Consultation Response from KC, Conservation and Design
2020/94197 78, Wellhouse Green, Golcar, Huddersfield, HD7 4ET
Listed Building Consent for erection of two storey extension to side (within a Conservation Area)
Date Responded: 30/09/21 Responding Officer: Craig McHugh Responding Ref: CV2/267
REVISED following receipt of further information by email from the applicant
Significance of the heritage assets affected

Proposed side elevation (1:100)

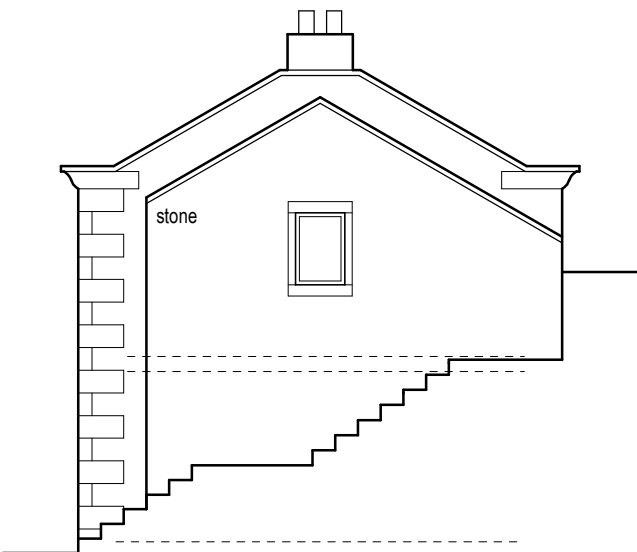
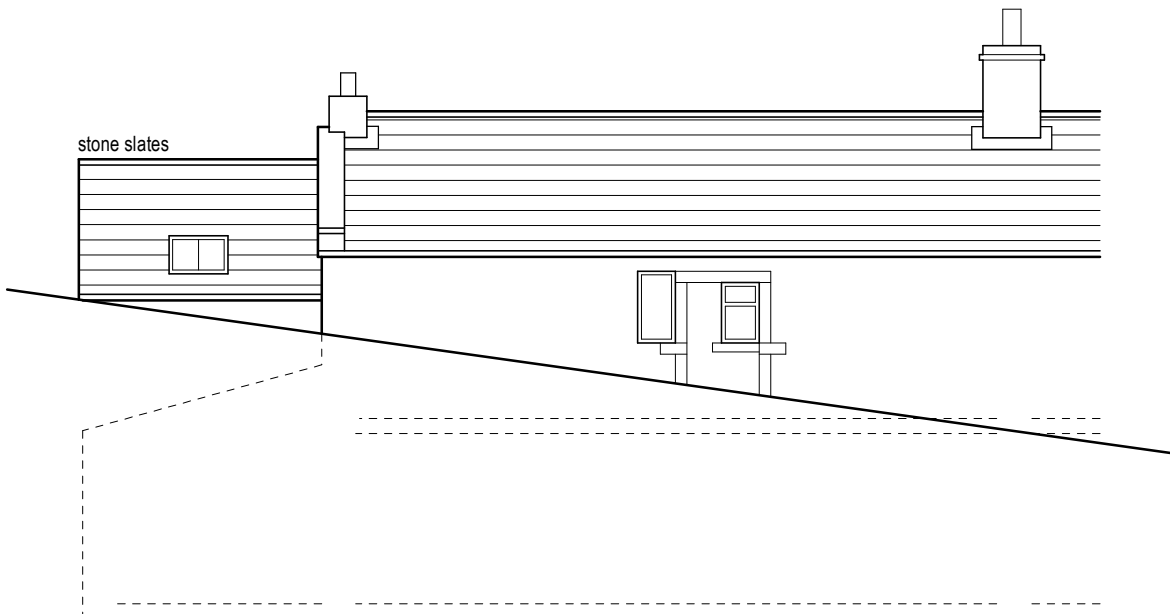
The proposed development would result in the loss of the lean-to extension, the first-floor windows and the blocked attic windows. The lean-to extension has been previously modified/ partly rebuilt. The window openings are original. The proposals would neither preserve nor enhance the listed

building, they would cause a moderate level of harm, that harm would still be less than substantial harm.

Block plan (1:200)

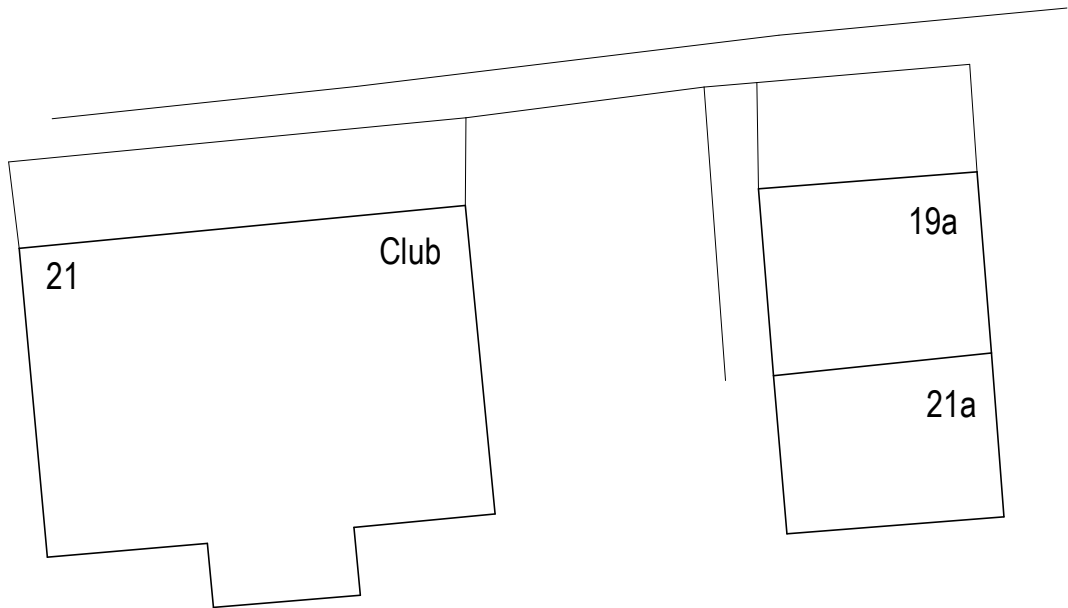
It is also noted that a fence has been erected to the front of the property on top of the boundary wall without listed building consent. An outbuilding has also been erected on the terraced garden. Both have impacted on the setting of the listed building. The extension combined with the shed would create a terracing effect that would be detrimental to the setting of the listed building.

Proposed first floor layout (1:50)

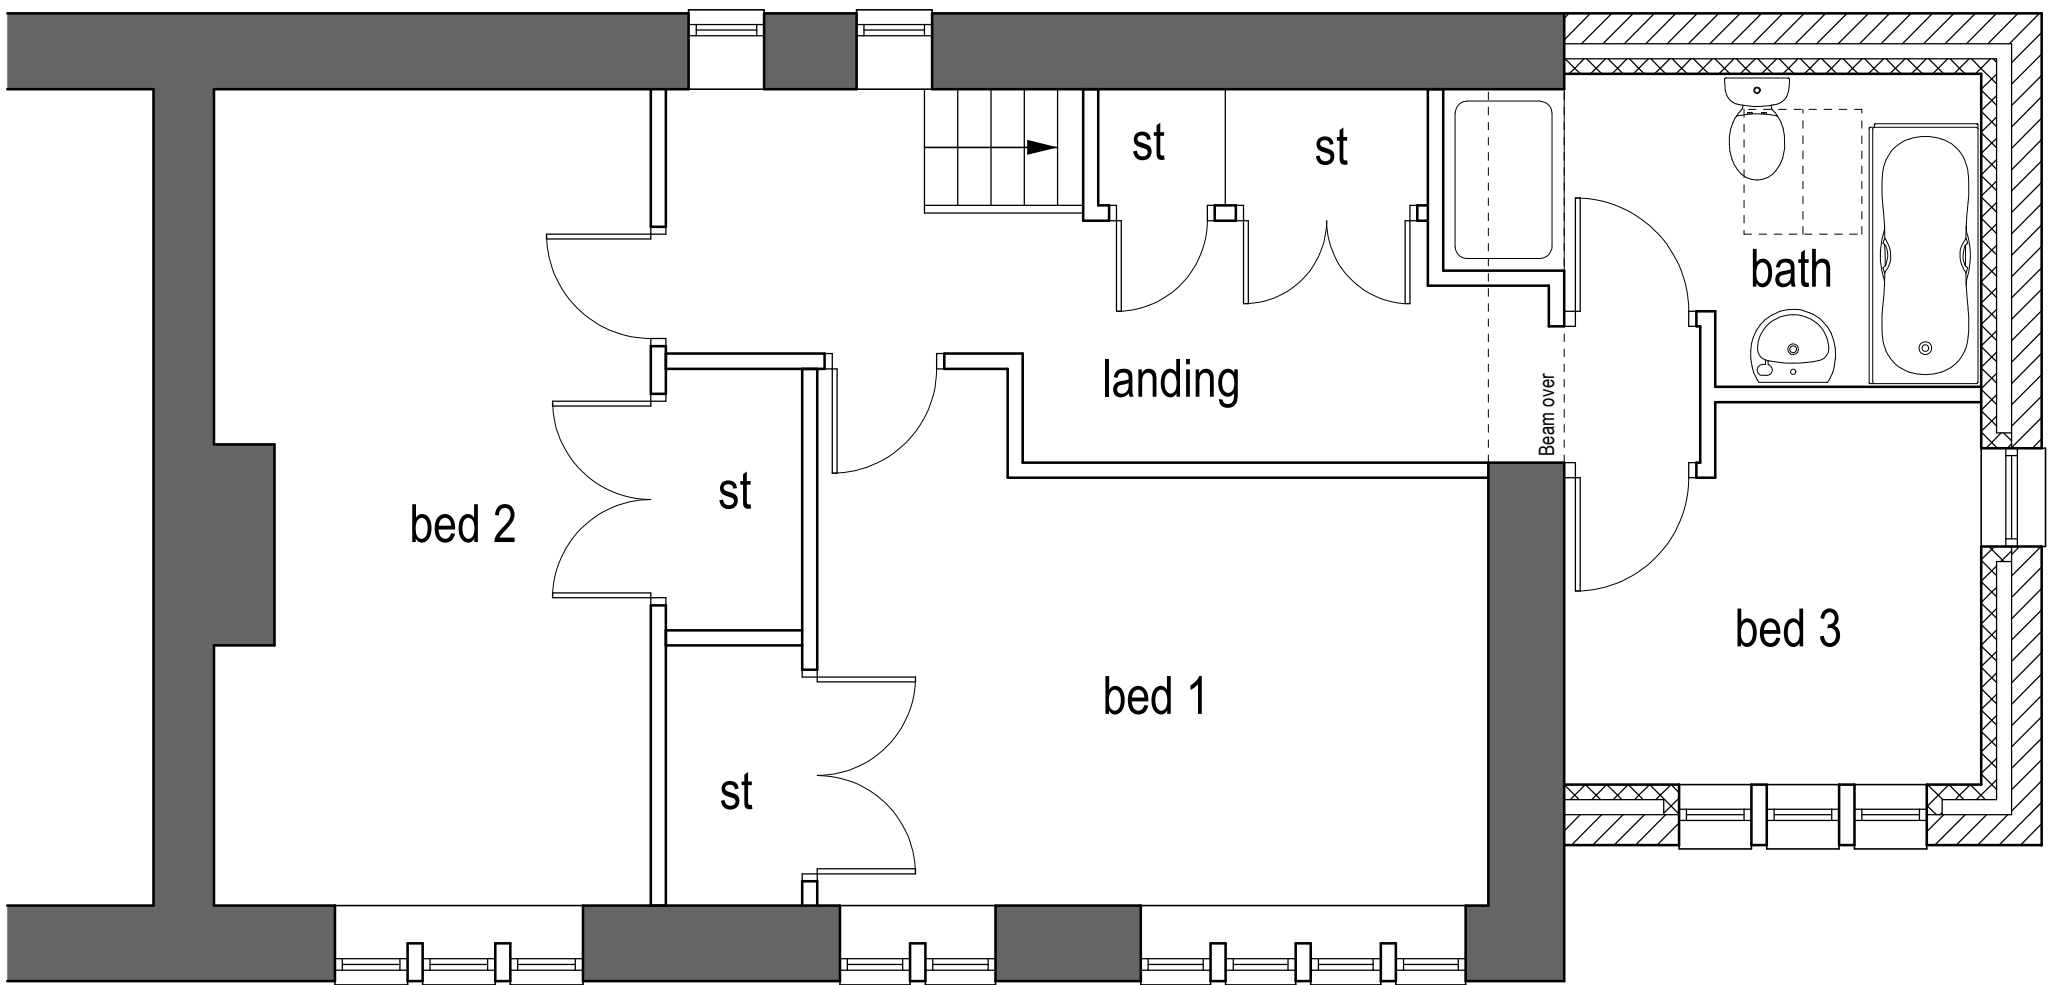
The proposed alterations would result in a large opening being formed at first floor between the existing house and the extension. This is in the vicinity of the chimney breast below (dining kitchen). There is no chimney breast shown on the plans at first floor in bedroom 1, the applicant has commented that this chimney breast would be unaffected but no evidence (photographic or amended plans) has been submitted to show that would be the case. However, photographs from around the time of listing show that the building previously had a chimney stack (now truncated without listed building consent) likely sufficient to serve two fireplaces.
